Planning Application Ref: AW/250/19/HH

Location: 19 Kingsway, Aldwick, PO21 4DQ

Description of works: **Extension to driveway to front & widening driveway gate. This application affects the character & appearance of the Craigweil House Conservation Area**

Proposed

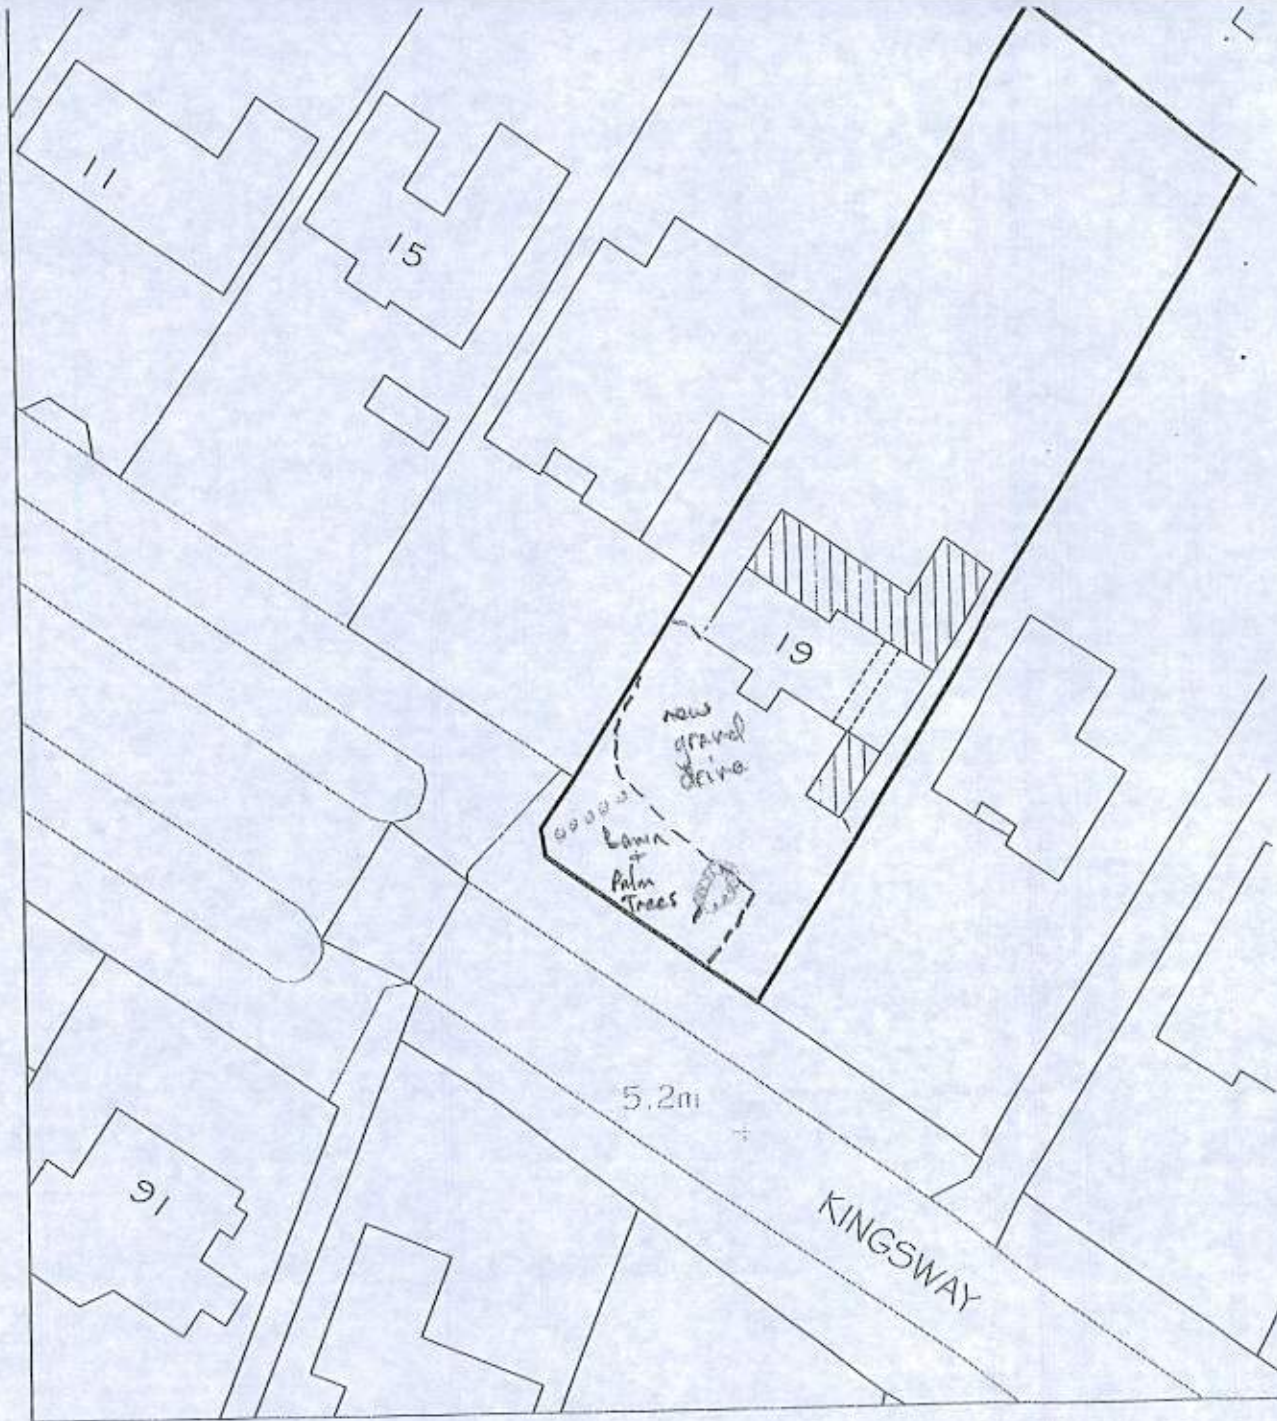
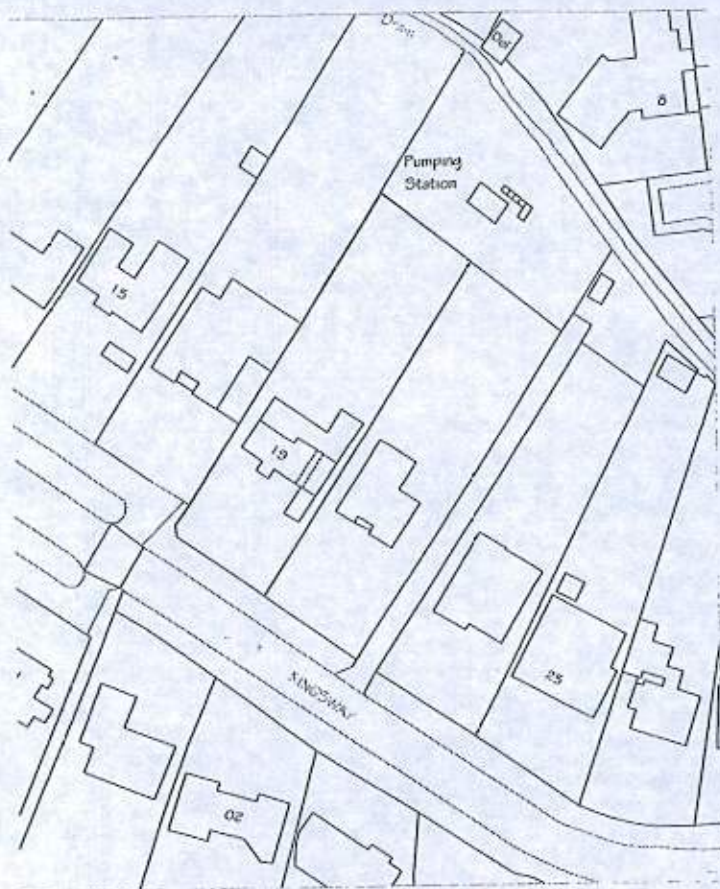
- There is a sketch plan (illustrative only) and insufficient engineering detail in support of this proposal; to be able to determine the full extent of its impact on trees, both above and below ground level. One can only assume the existing driveway width (between the garage and garden/verge interface) is to be retained as it is. Whilst welcome, we must understand how the existing construction is to be demolished, the new installation applied, and the type of materials to be used. There is also the gate-widening, installation of border sleepers and preparation of shrub borders/planting within the nominal root protection area (RPA) of significant trees to consider. All these items should be properly addressed within a detailed arboricultural report and to our satisfaction. Most of these items have been addressed in respect of their potential impact on trees, although outstanding is detailed description of how and what type (treated timber?) of sleepers are to be installed and ground preparation for shrub borders within the RPA of retained trees. These can be addressed to our satisfaction at the pre-commencement site meeting.

Drg No
NJCL 576 B

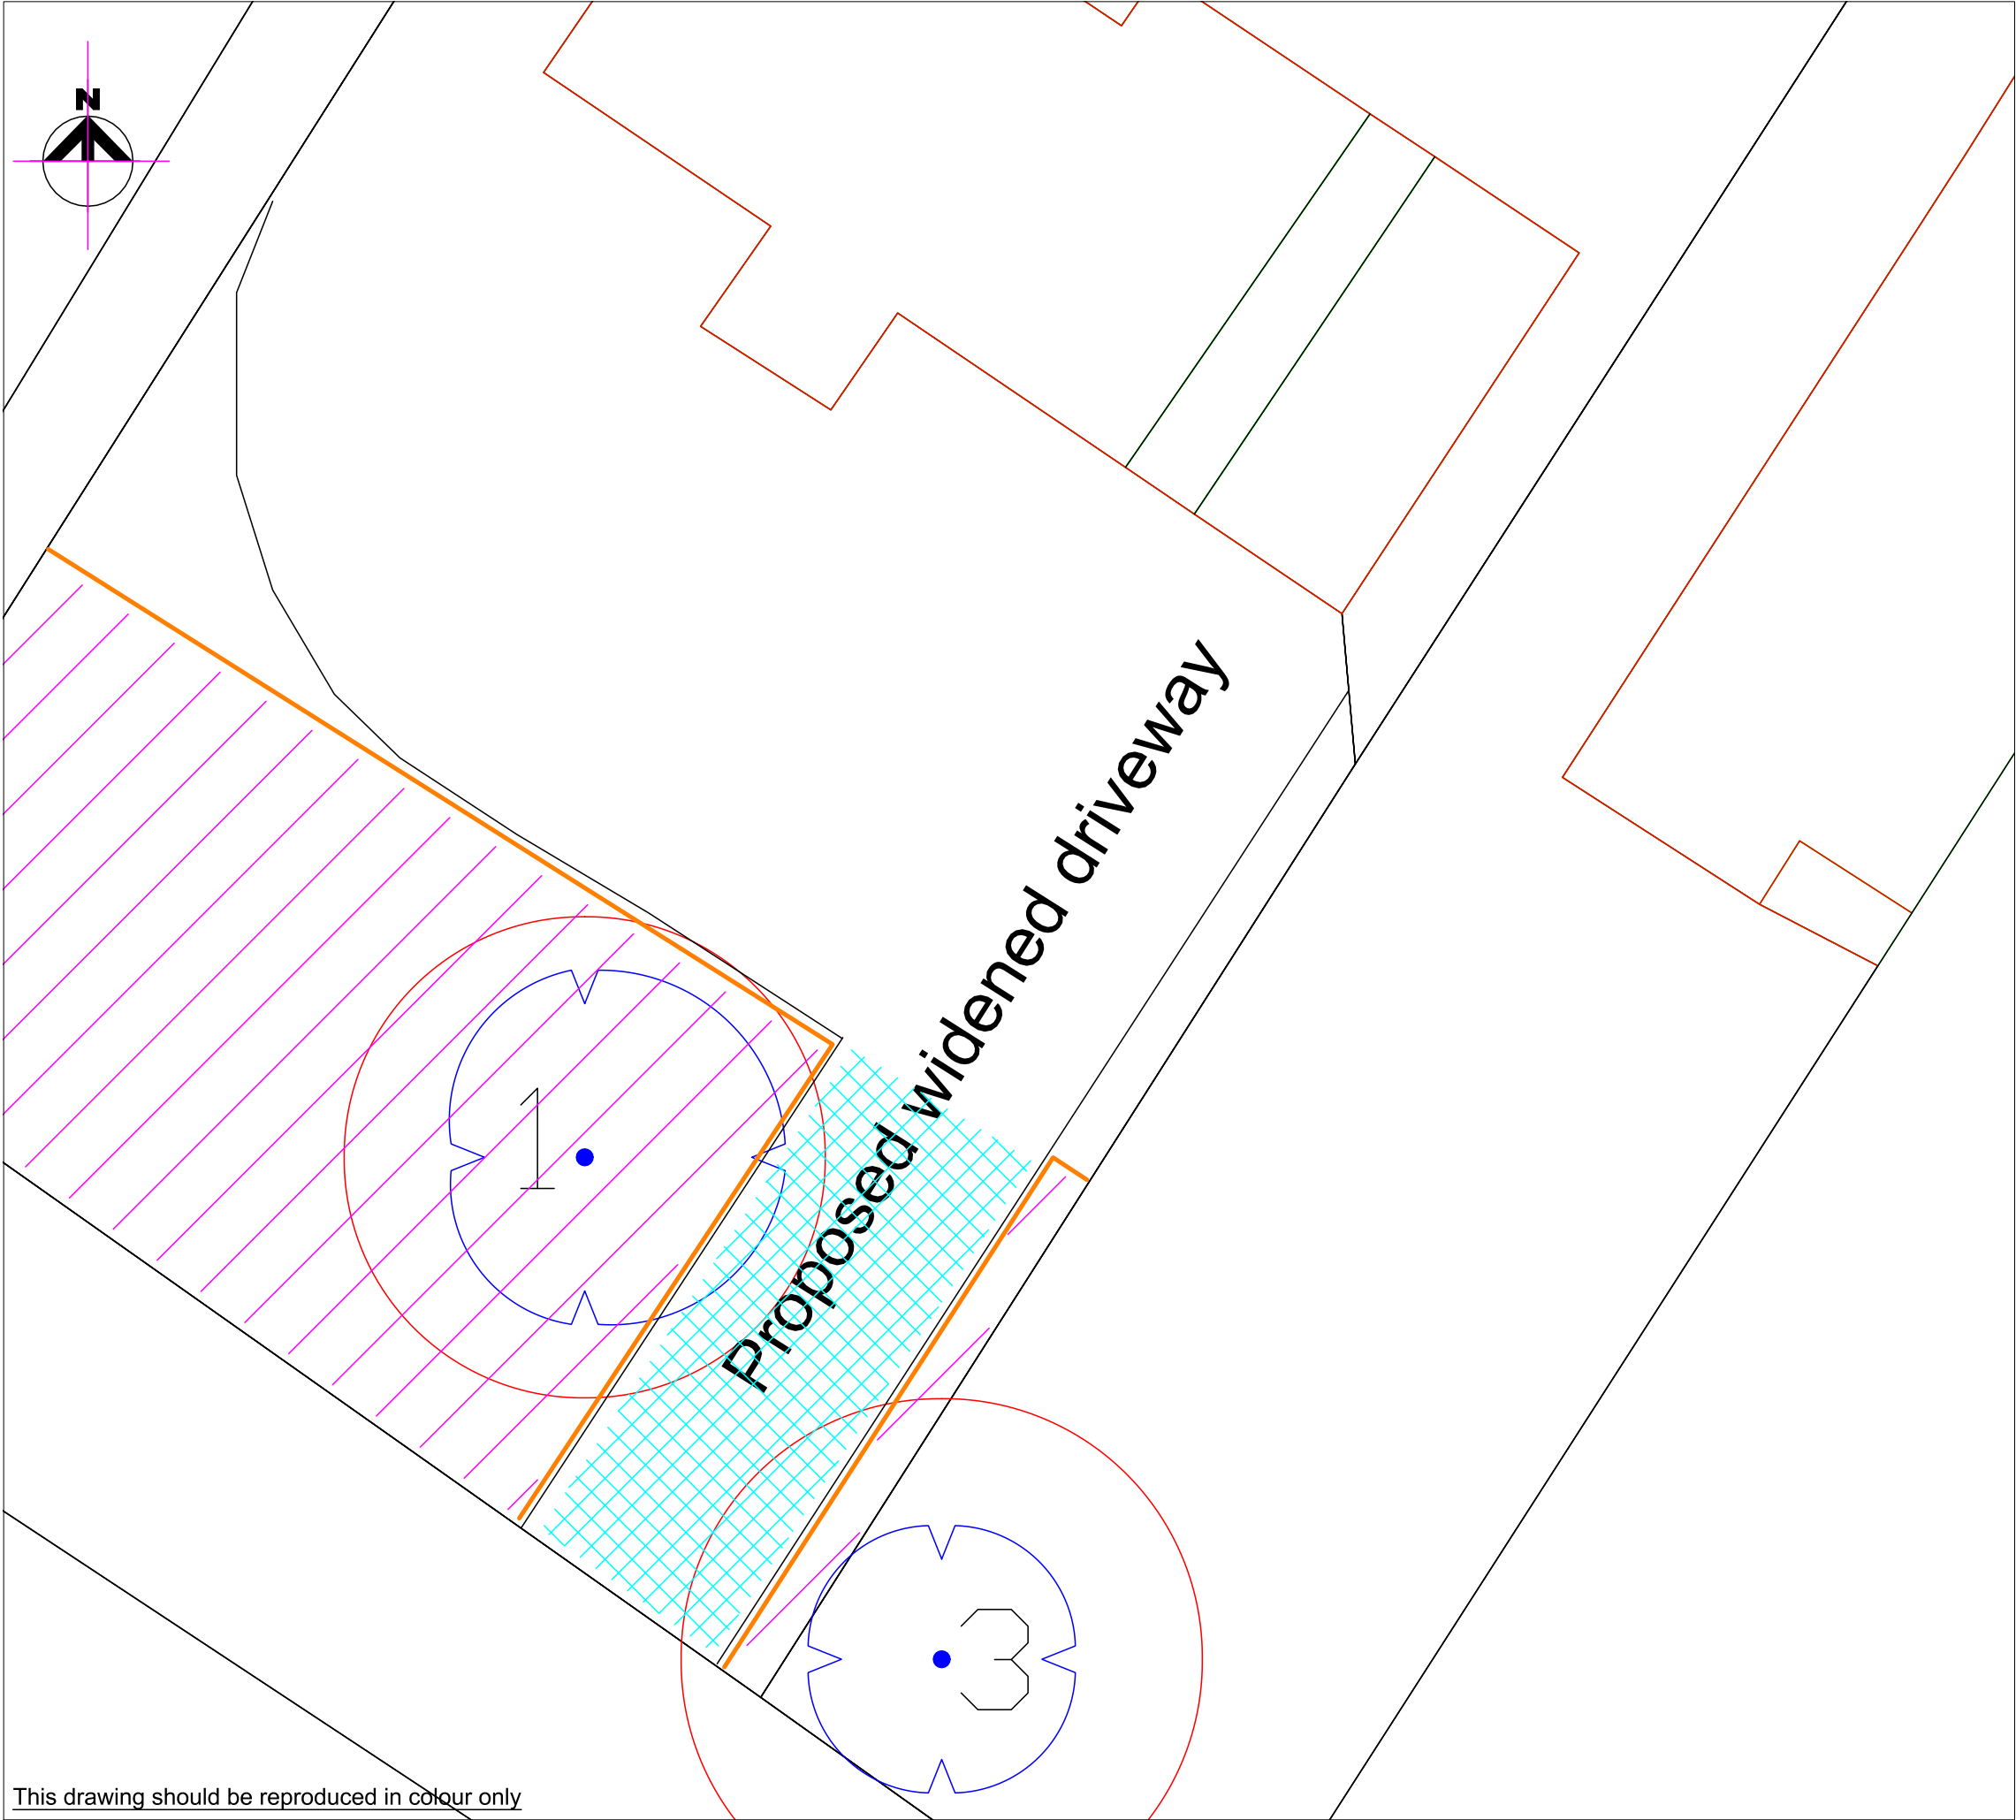
- The extent of RPA incursion as shown on the tree protection plan is within acceptable tolerances and given the probable impact on retained trees, does not require the use of a 'no-dig' engineering solution for the driveway construction. The tree protection plan identifies where the construction exclusion zones are to be positioned. Although I have not had sight of the method of demolition, I will be satisfied with the project arboriculturist's supervision at that key stage of development and submission of monitoring records with accompanying photographic evidence to demonstrate full compliance with their own report.

- The tree protection plan shows a driveway width of 3.5m which I understand exceeds that which has been subsequently proposed. Clearly a narrower driveway construction of stated 2.5m will provide an opportunity for less RPA incursion and I would expect that to be reflected in the final position of protective fencing, to be assessed at pre-commencement site meeting.
